KIRKLEES METROPOLITAN COUNCIL INVESTMENT & REGENERATION SERVICE

DELEGATED DECISION TO DETERMINE APPLICATIONS FOR CONSENT, AGREEMENT OR APPROVAL REQUIRED BY CONDITION

Reference No:	2025/44/90689/W
Site Address:	Penistone Road/, Rowley Lane, Fenay Bridge, Huddersfield, HD8 0JS
Description:	Discharge of details reserved by conditions 16 (temp drainage), 25 (retaining walls), 26 (surface water attenuation pipes), 31 (road network) on previous permission 2020/92307 for outline application, including the consideration of access, for erection of residential development (up to 75 units)
Recommending Officer:	Katie Chew

DECISION – Discharge of Condition – Split Decision

Dt: OF
OF: JM
Date: DEC 2024
Scale: 1/50 @A0
Dwg No: E23/8060/043_02A

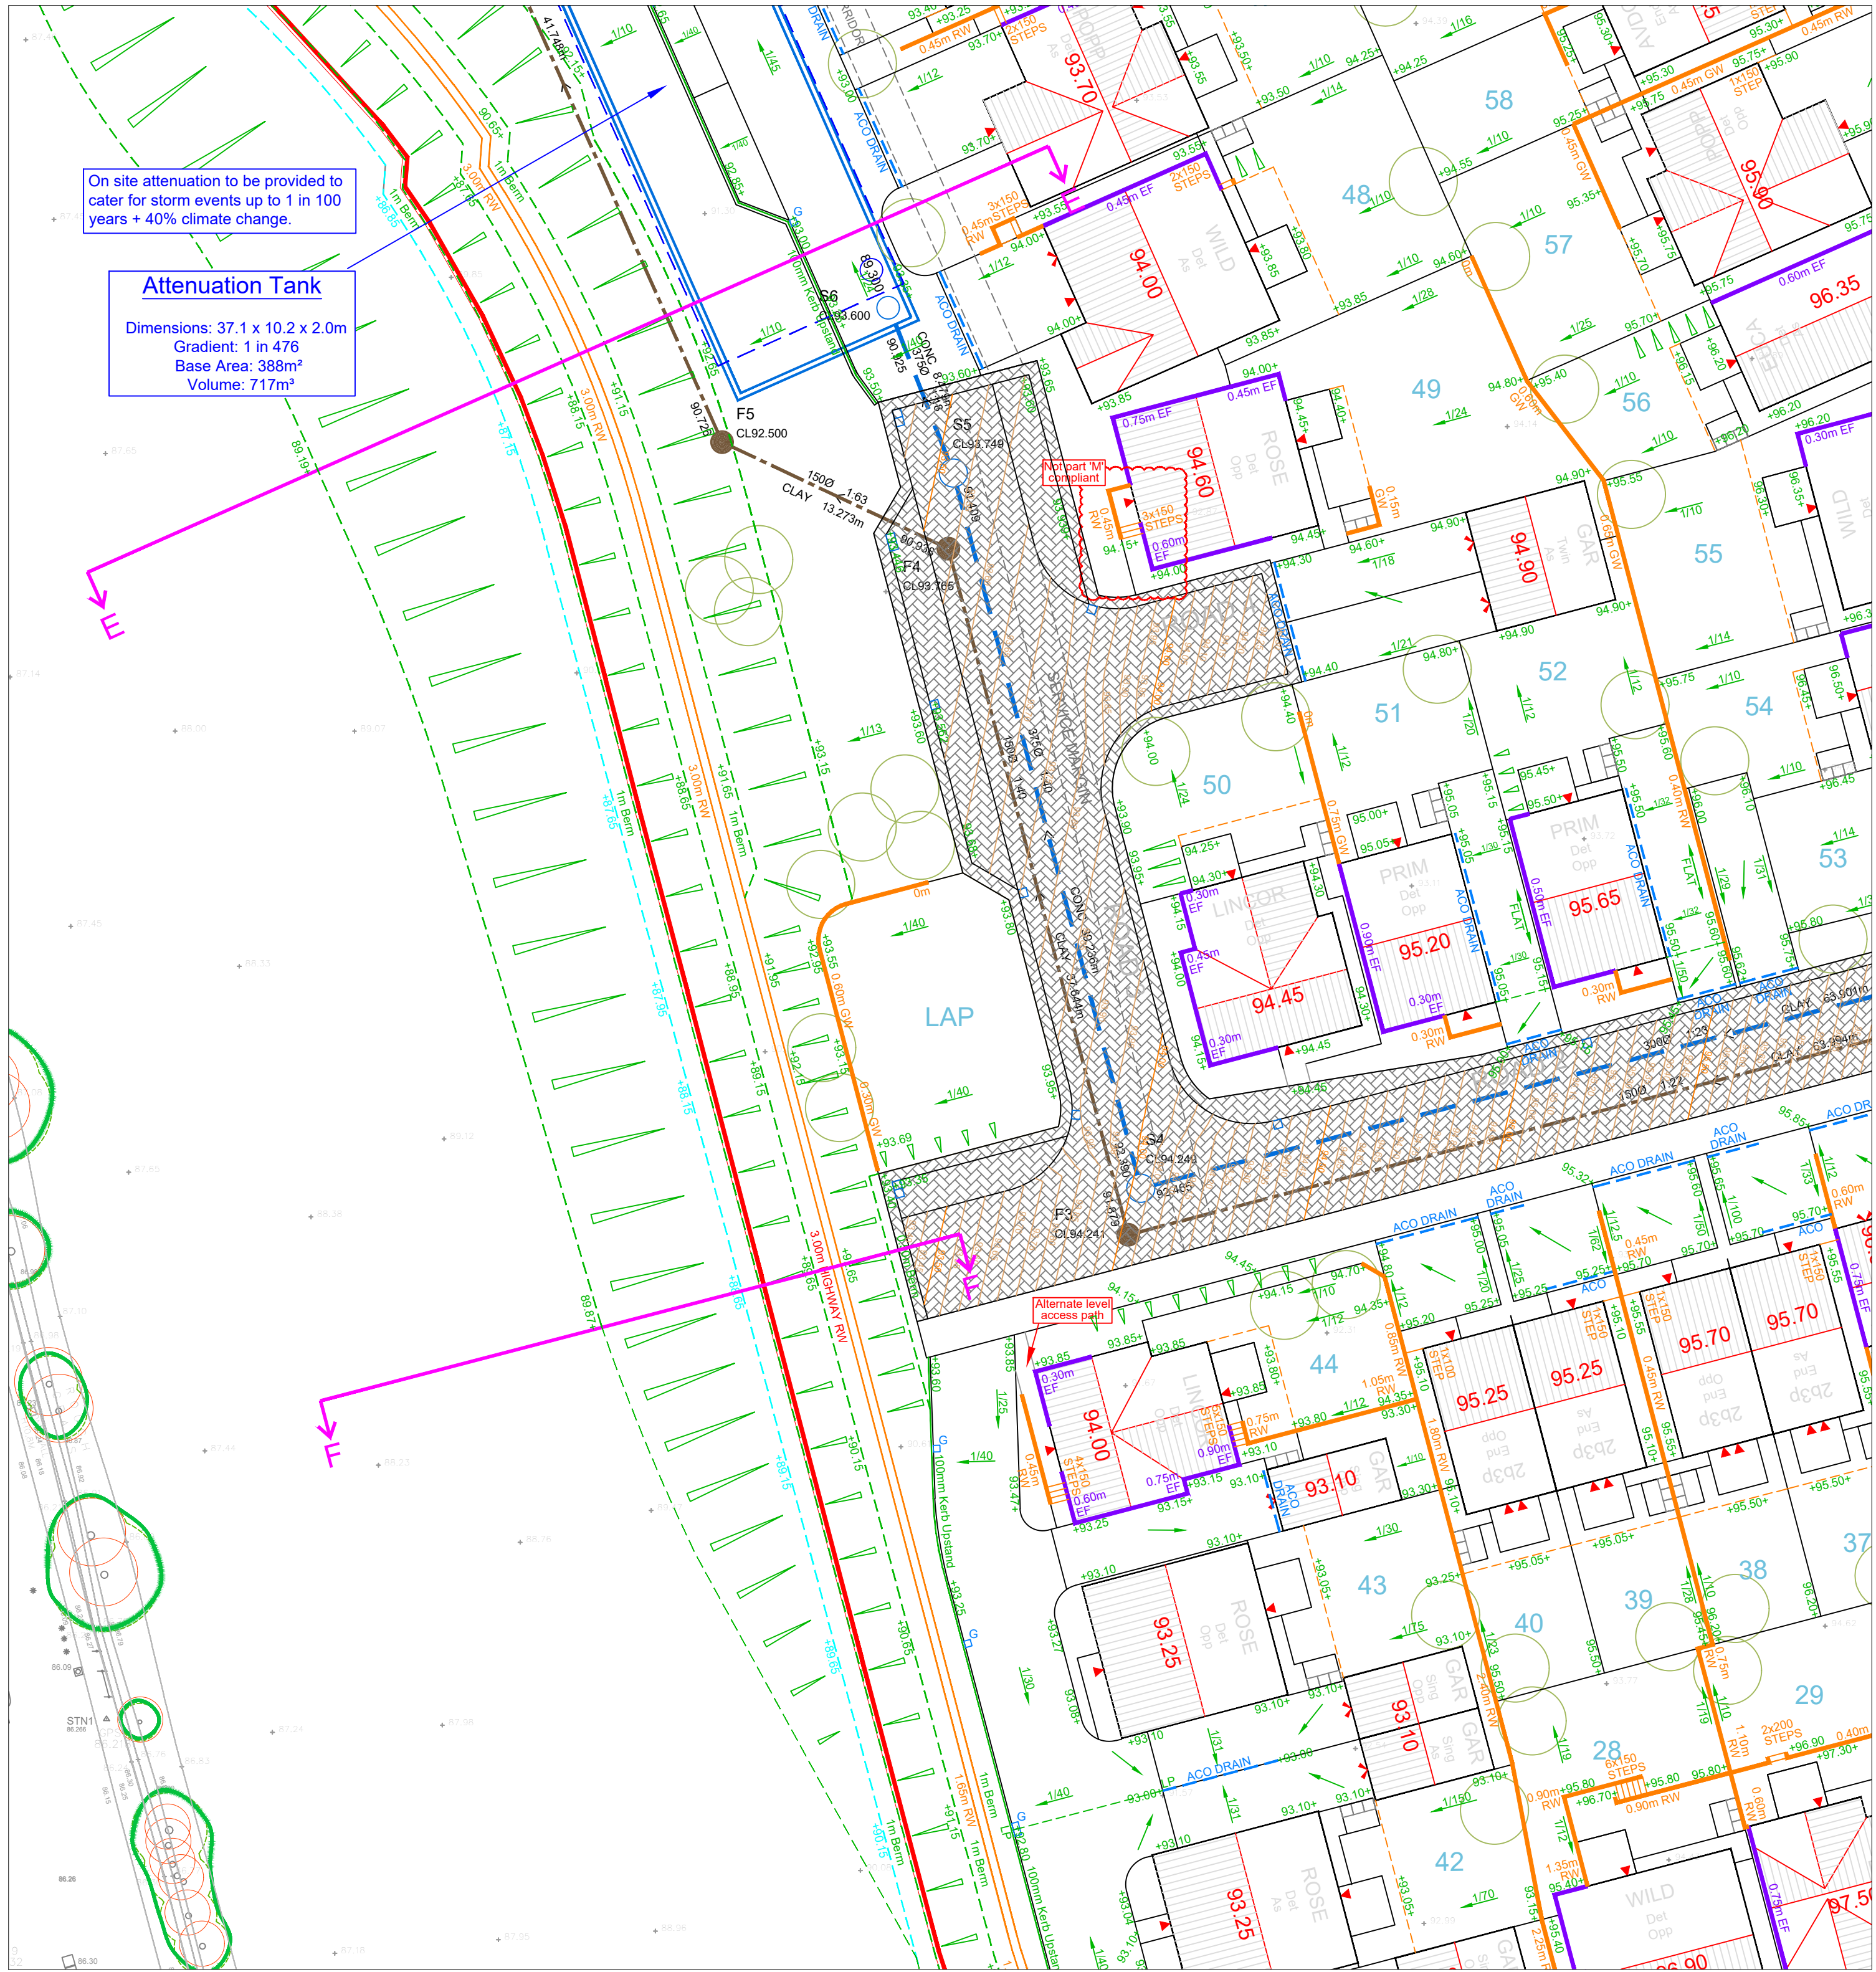
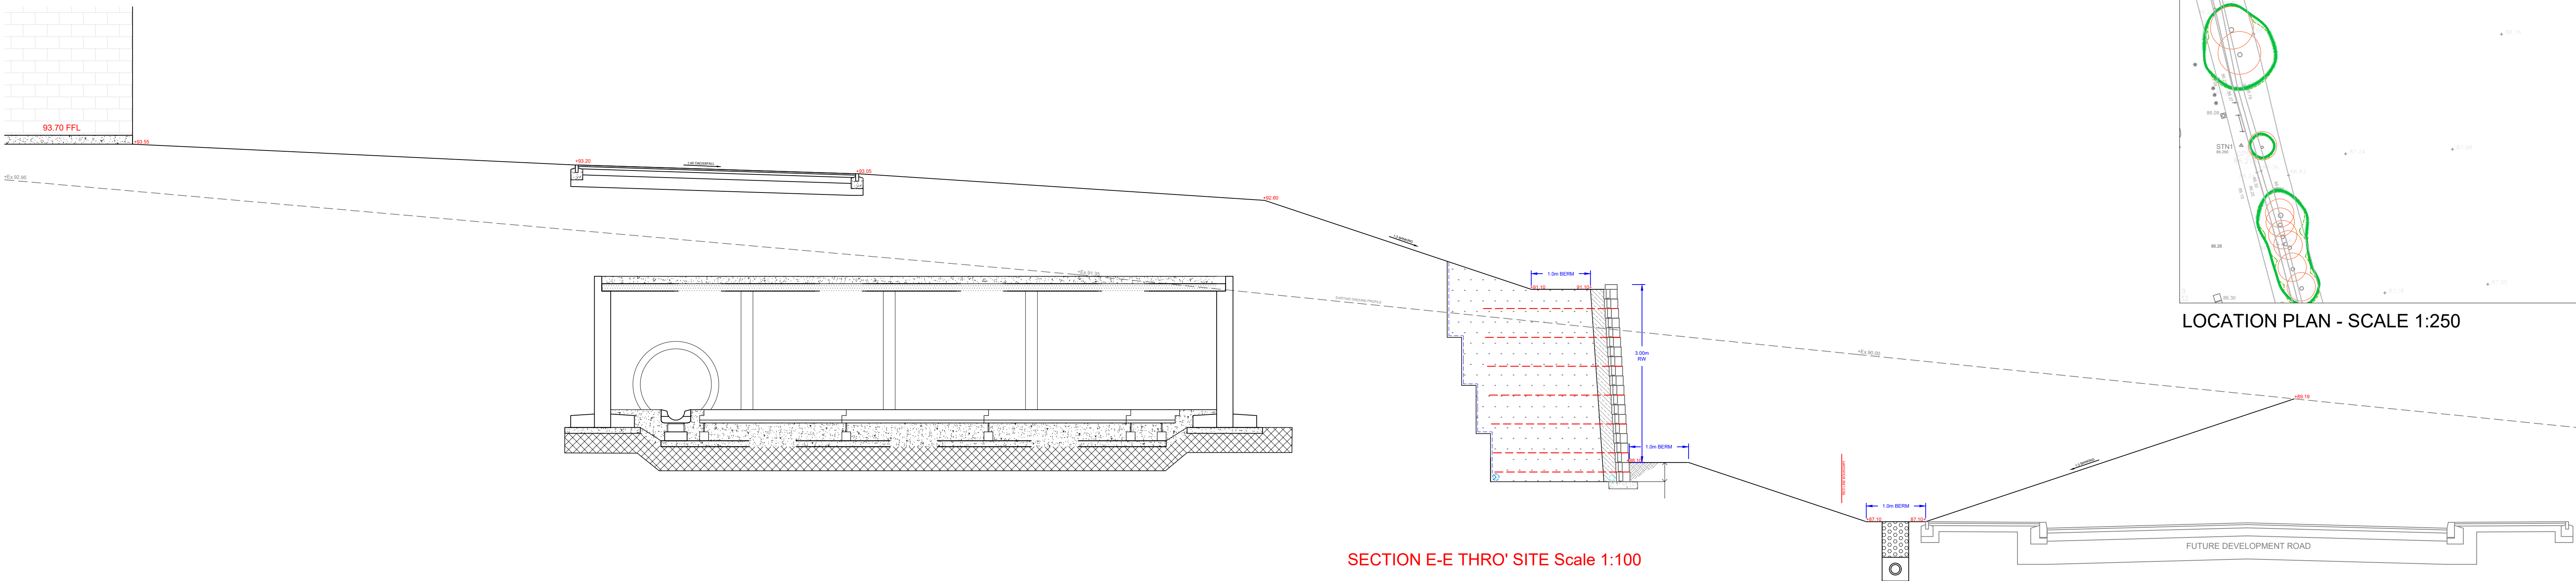
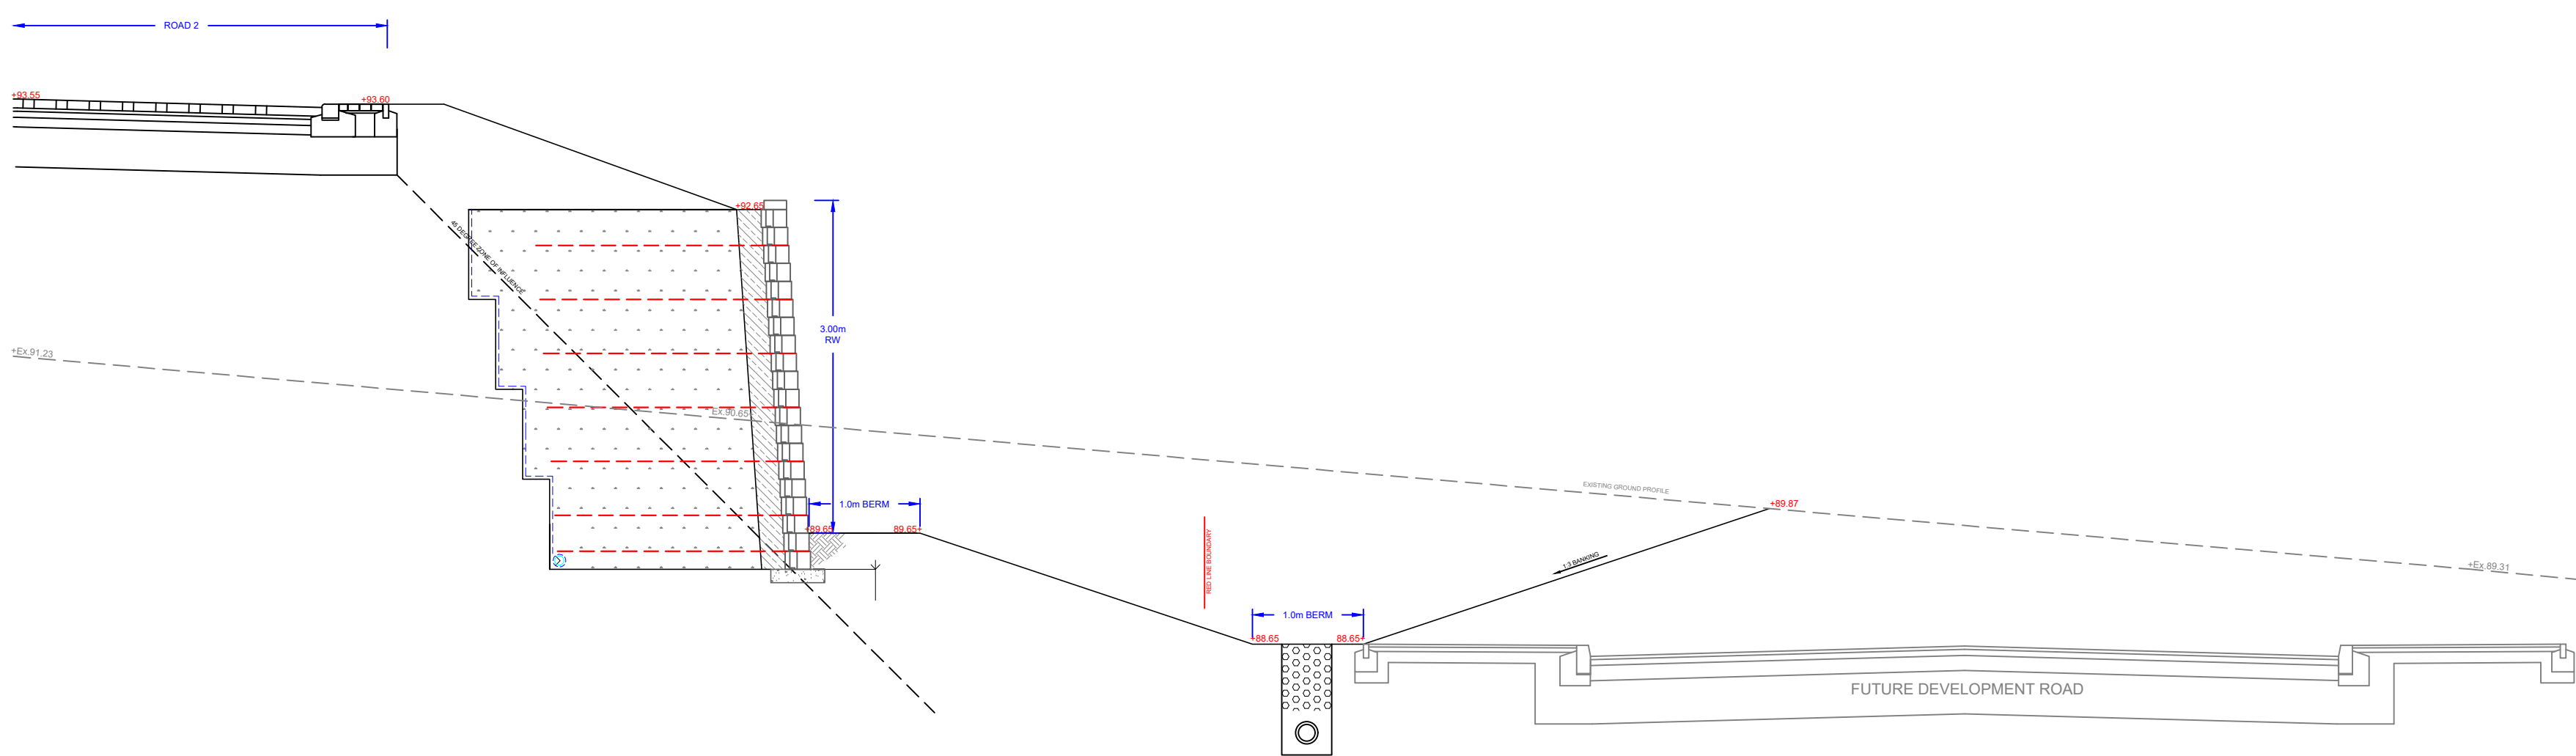
1) Submission of suitable of external works drawing for the whole site with appropriate keys for the relevant proposed retaining walls/embankments adjacent to the highway, adoptable highways and the confirmation of location and status of the road labelled “Future Development Road” as well as specifying the lateral dimensions between the proposed structures and adjoining Road on the submitted sectional details to ascertain whether these retaining structures will be liable to a formal technical approval via submission of AIPs.
